Harnett County Government Complex
307 Cornelius Harnett Boulevard
Lillington, NC 27546

Re: Status of Improvement Permit Application #05-5-11720

On March 31, 2005, an Environmental Health Specialist from the Harnett County Health Department attempted to evaluate your property for the purpose of issuing an Improvement Permit. This individual was unable to evaluate your property for one or more of the following reasons.

*Revised*  
SITE PLAN APPROVAL  
DISTRICT BAZOM USE DWMMH  
#BEDROOMS 4  
3/22/05 PJR  
Date Zoning Administrator  
4/4/05

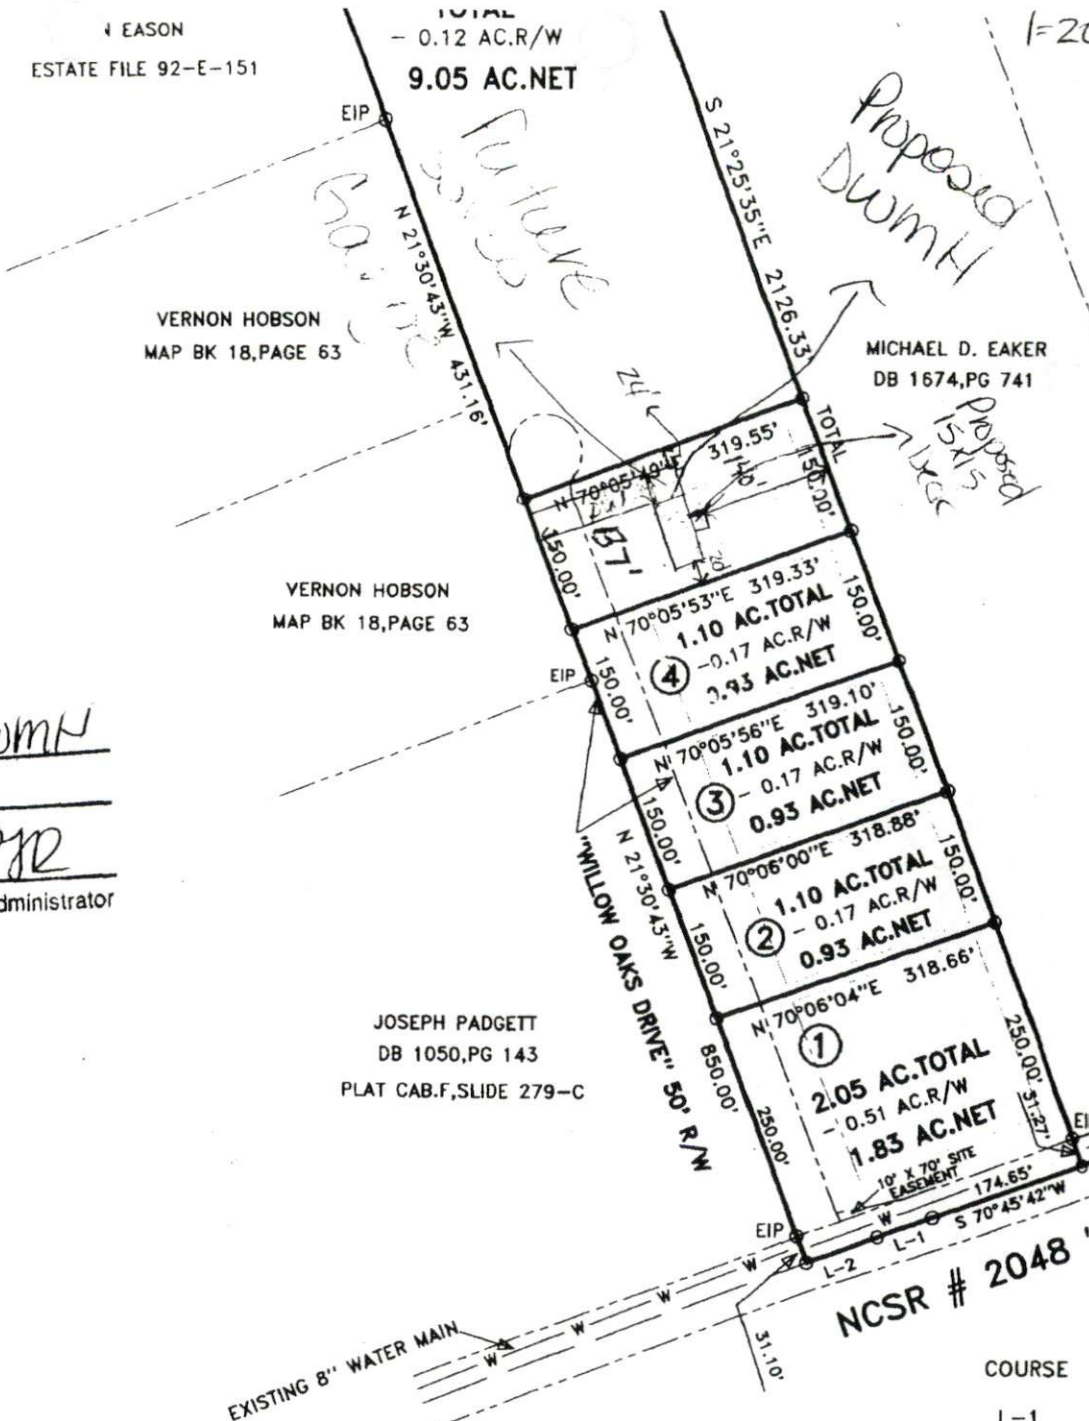
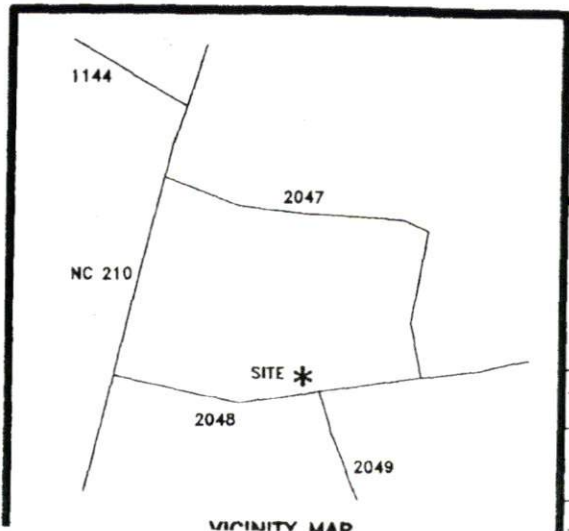
- 1. Property lines/corners not marked or labeled
- 2. House corners not marked or labeled
- 3. Directions not clear to property
- 4. Property needs brush or vegetation removed
- 5. Backhoe pits required
- 6. Other **Please move home as shown on my plan. Please make changes at Central Permitting.**

Stanley W. Jackson - Make These Change To Your house location
And Pump should not Be Required
